Application No: FG/170/20/T
Site Address: Verge opposite 18a Ocean Drive The Poplars Ferring BN12 5GJ
Description of works: Various works to 6 No. Austrian Pine trees.

Comments from the FPC Tree Warden

Plan showing location of trees

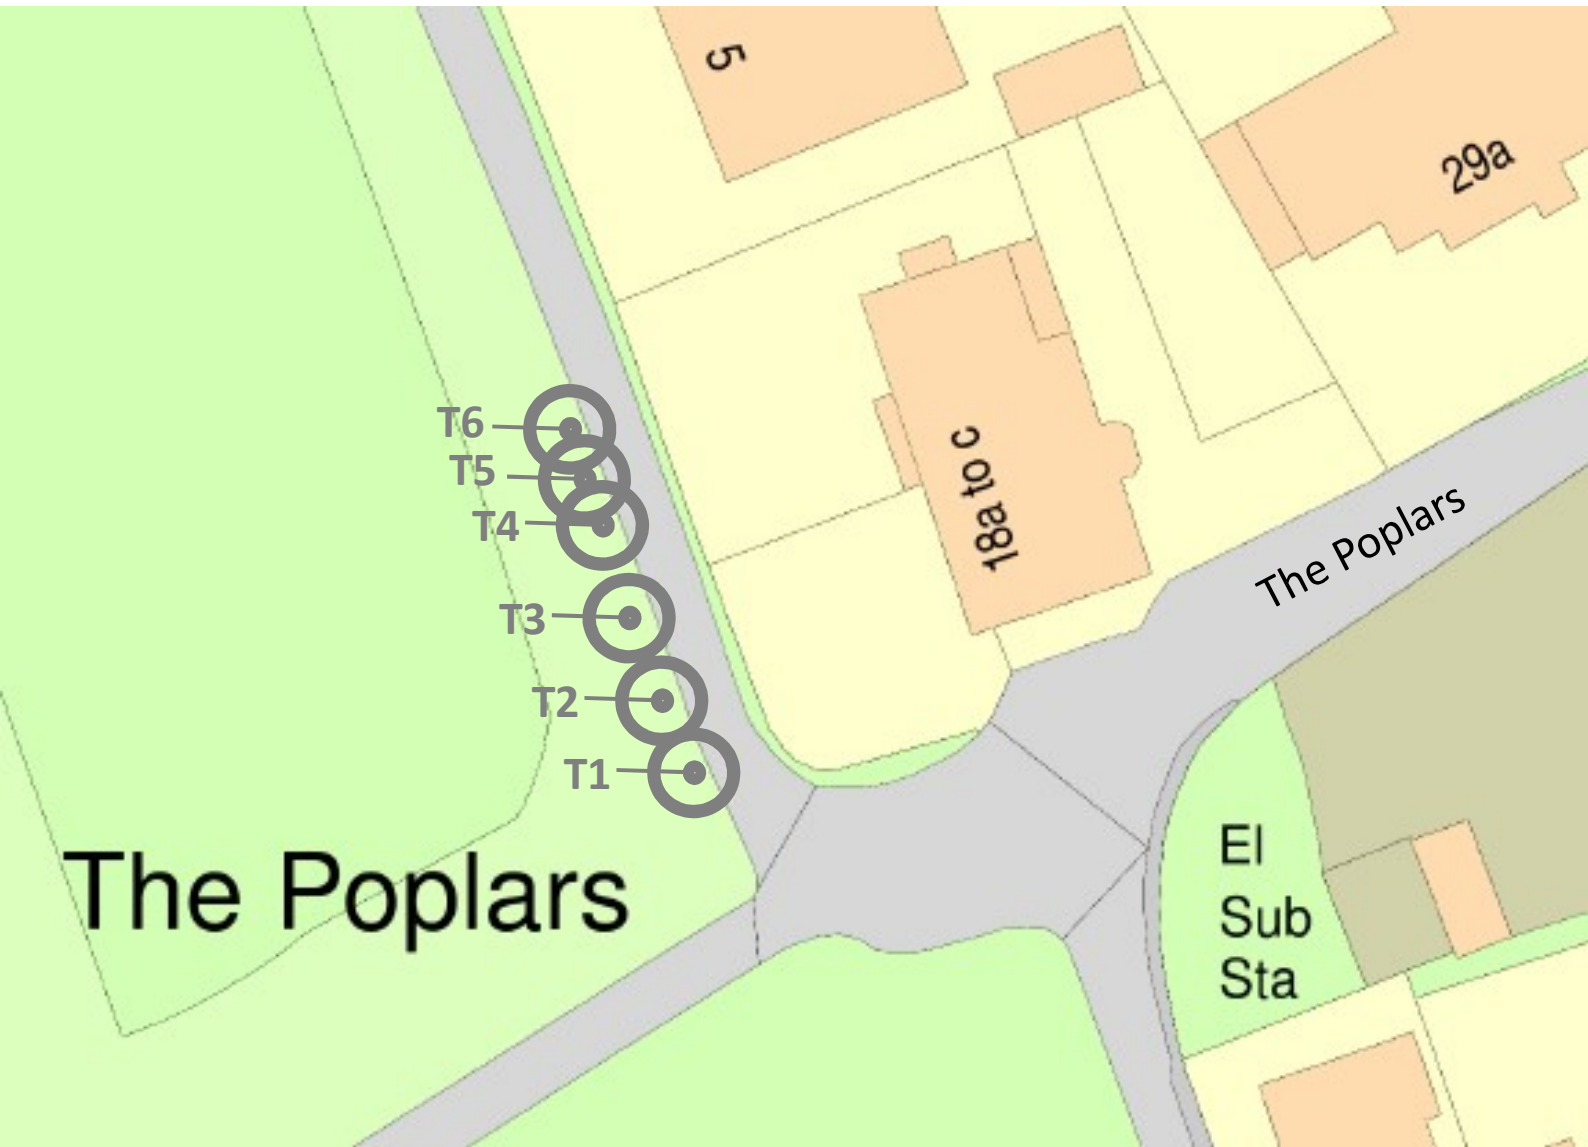
Having read the proposed works, there is no reason to support this second application as basically the proposed works are detrimental to the trees as reported earlier by the councils Tree Officer to application FG/44/20/T.

The TO may allow a small proportion of the works, some crown lifting but not reducing lateral spread as it will likely kill the remaining lateral growth. The trees are not in the best of health and suffer some wind damage.
